**PRELIMINARY DRAINAGE REPORT
FLYING HORSE NORTH PRELIMINARY PLAN AND
FINAL DRAINAGE REPORT FOR FLYING HORSE NORTH FILING NO. 1**

CCES COMMENT RESPONSES

FLYING HORSE NORTH
PRELIMINARY/FINAL DRAINAGE REPORT
FILING NO. 1 DRAINAGE MAP

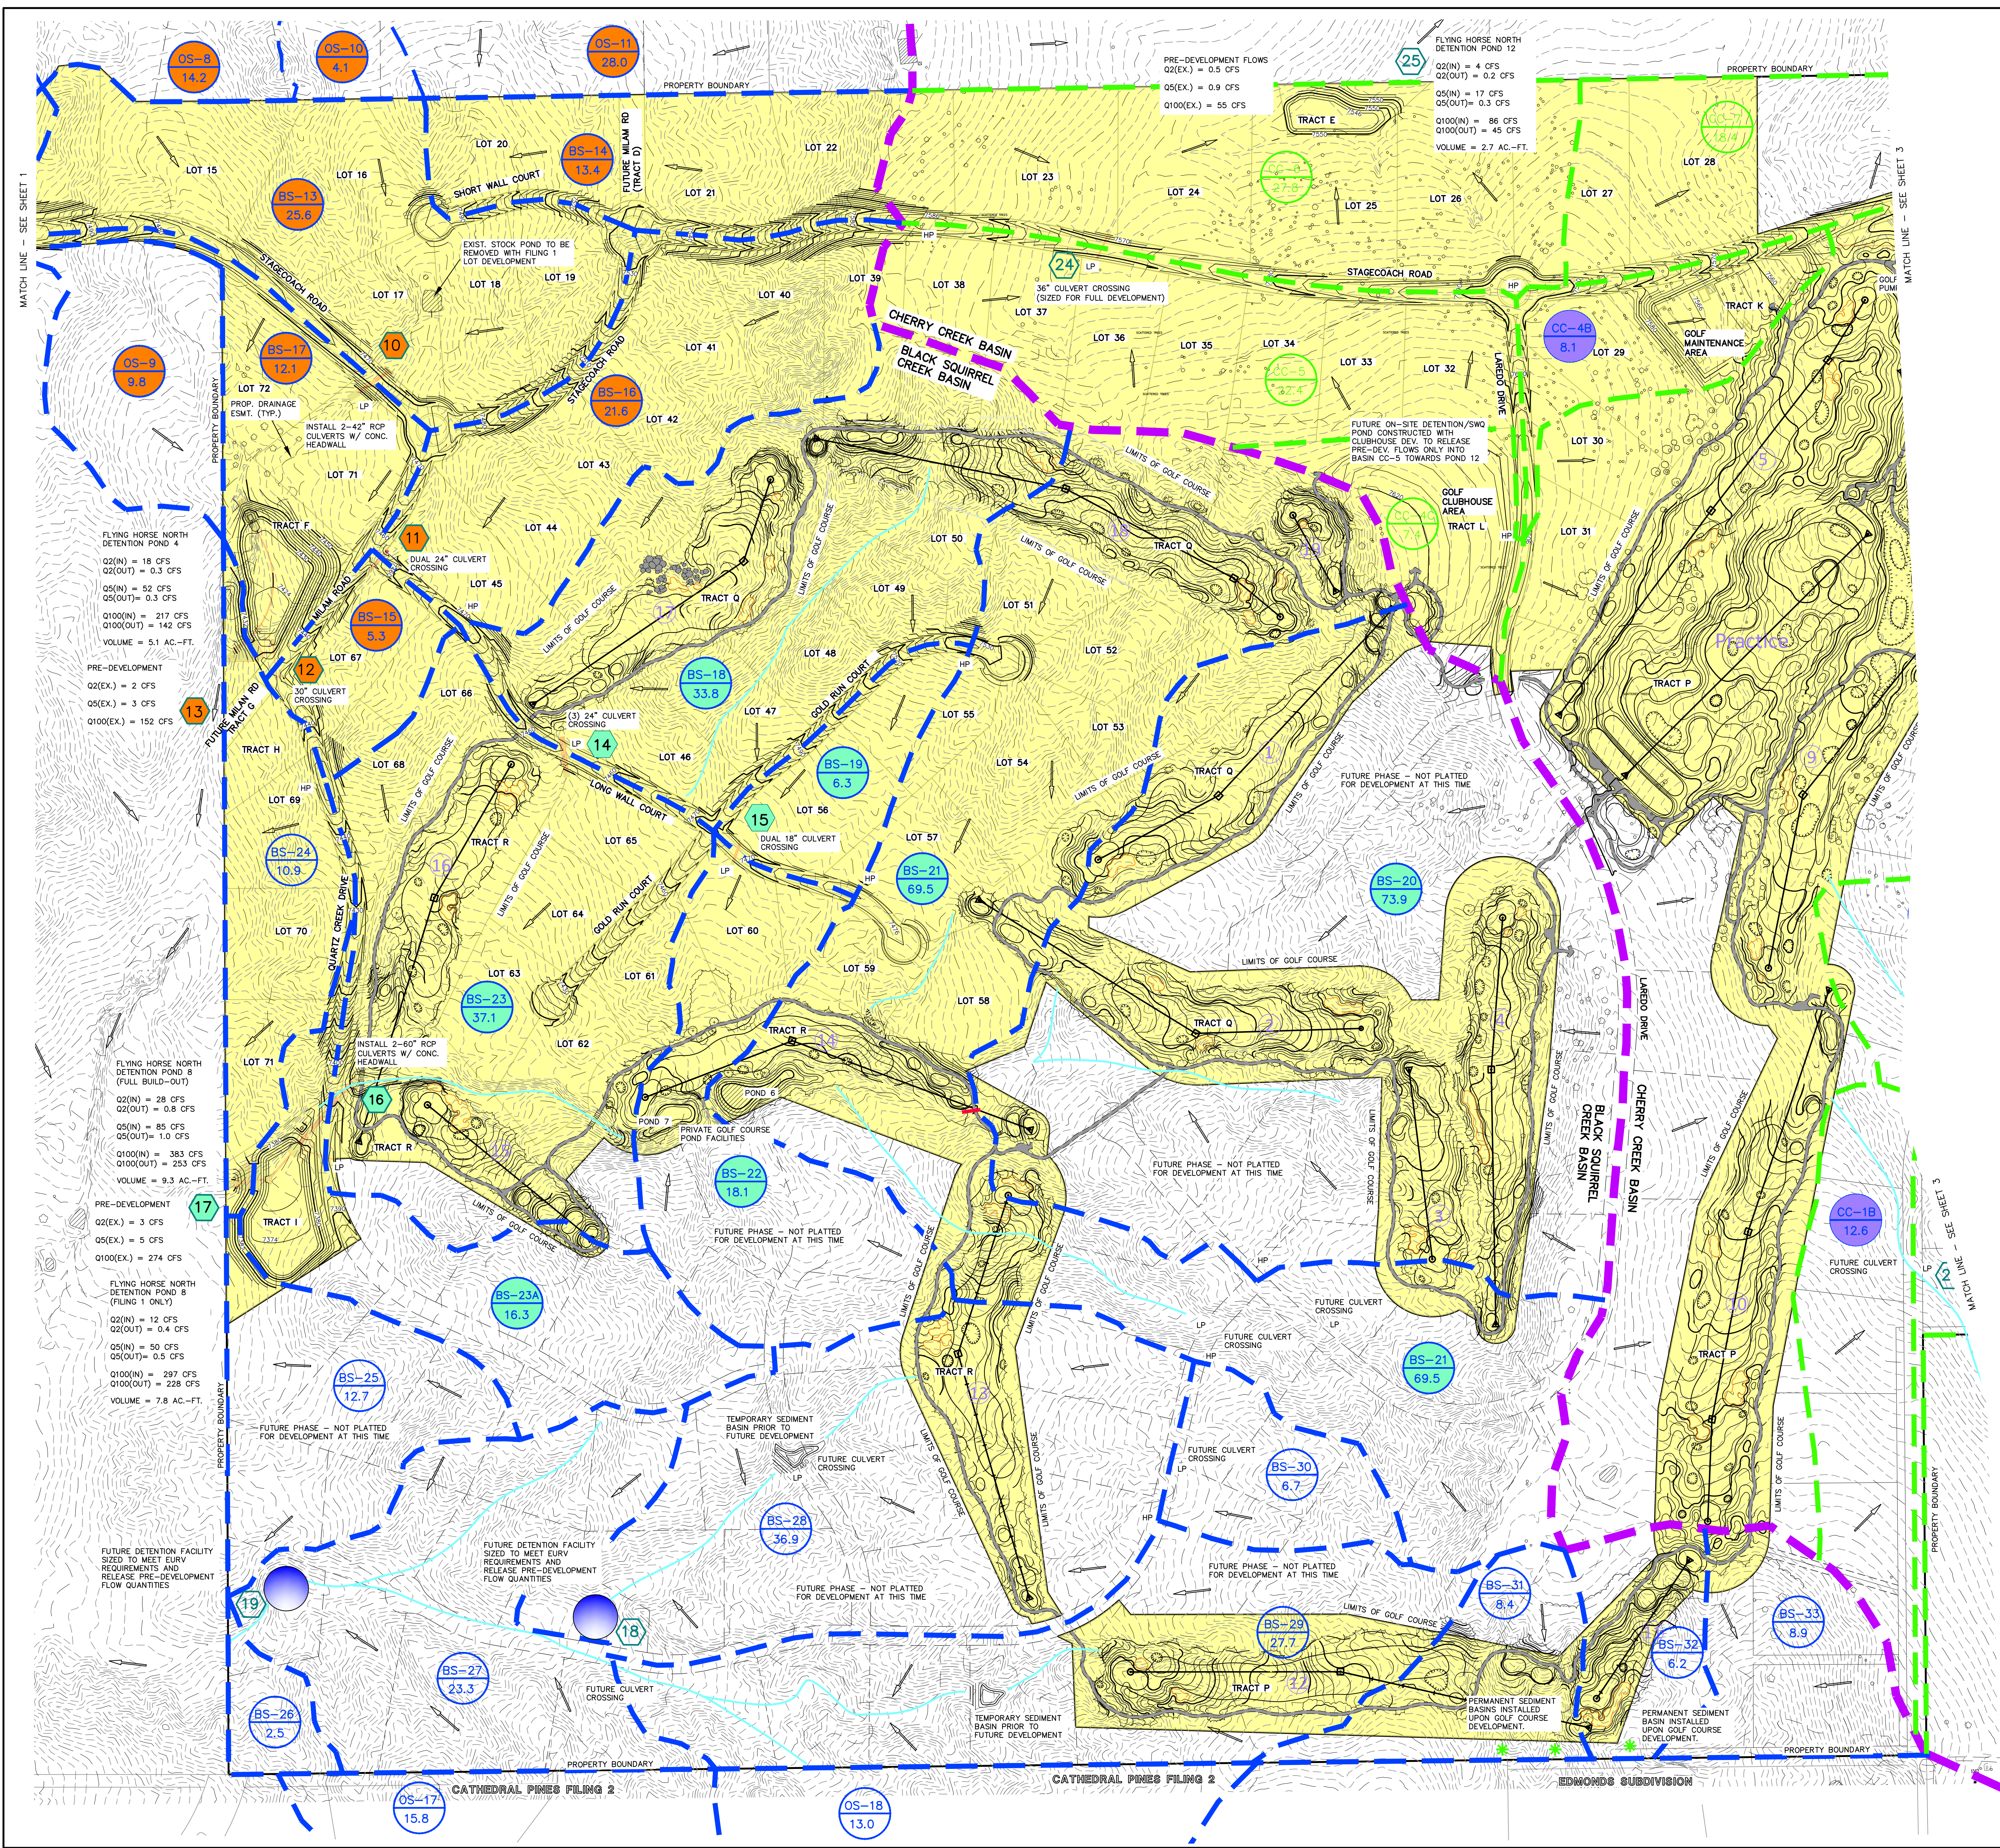
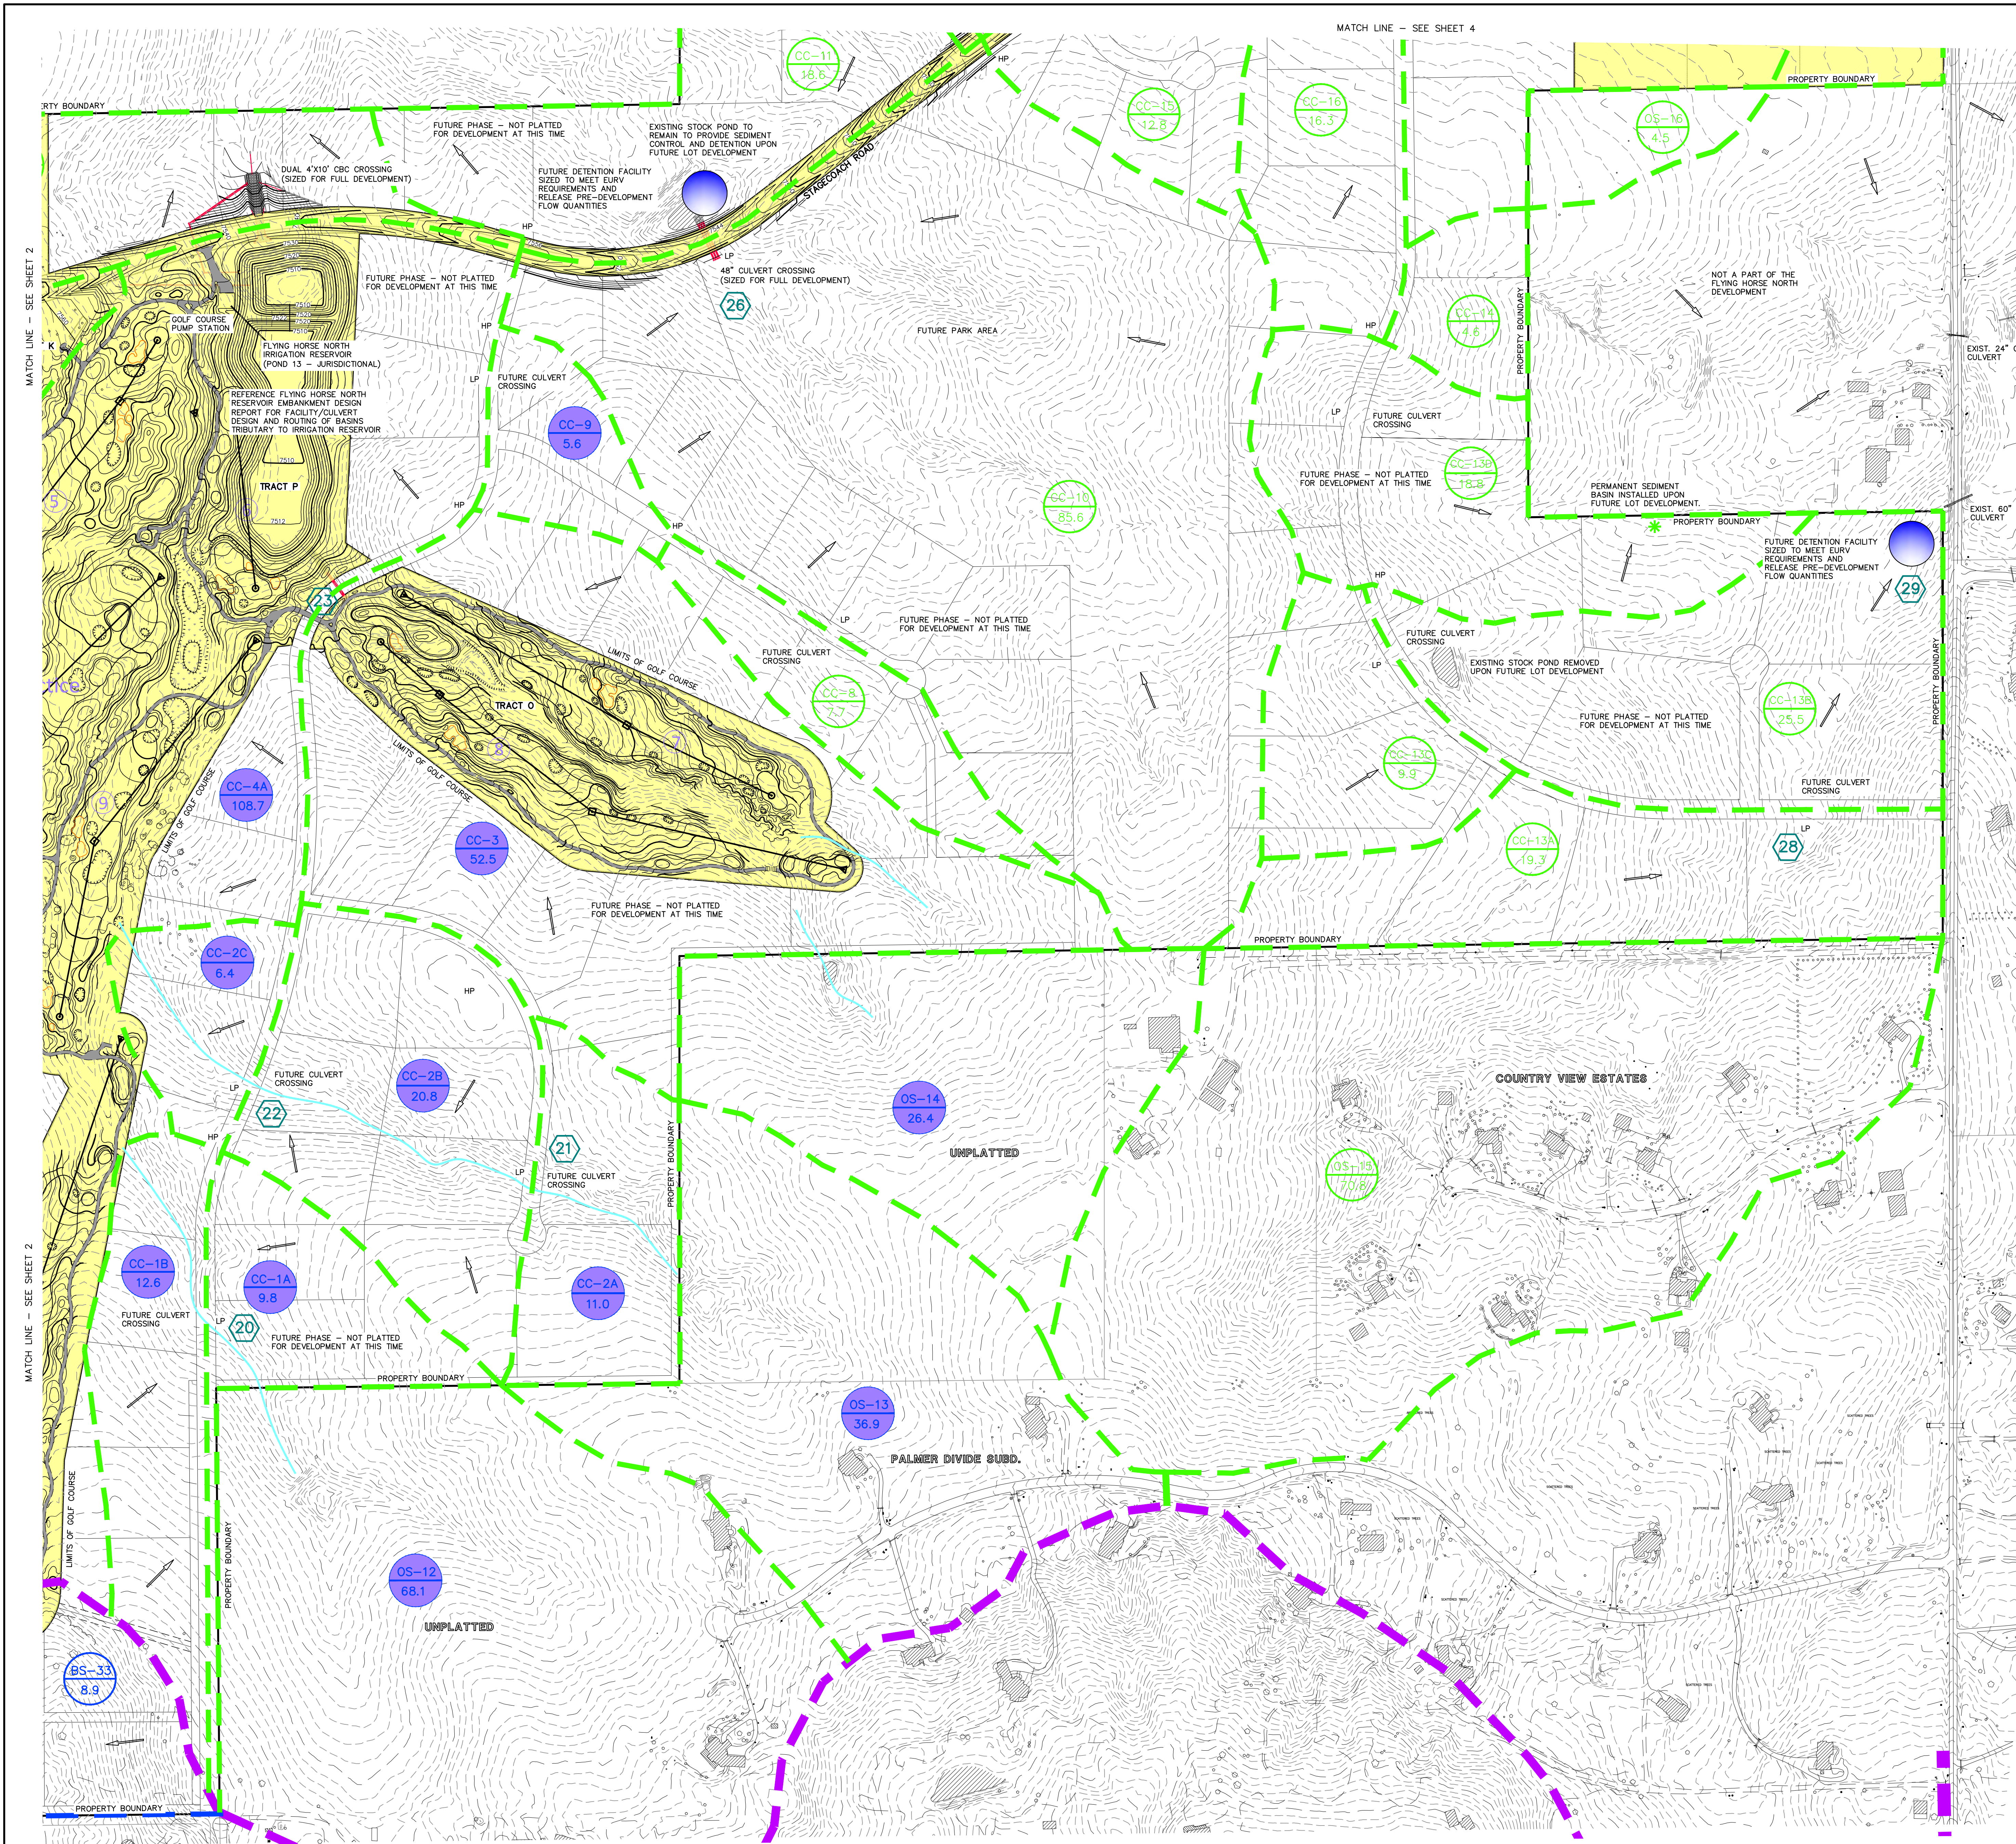
Include an existing drainage map and
provide the narrative for the sub-basin

Elaborate on where this drains to. From the drainage map it seems to drain into the future detention facility at DP 19. If this is the case then identify that ponds DP18 and DP19 must be designed/analyzed as ponds in a series.

Identify and discuss the emergency overflow path for Pond 18. It appears that it would cross over residential lots and into Pond DP19

BS-2
updated on map

see additional text in report
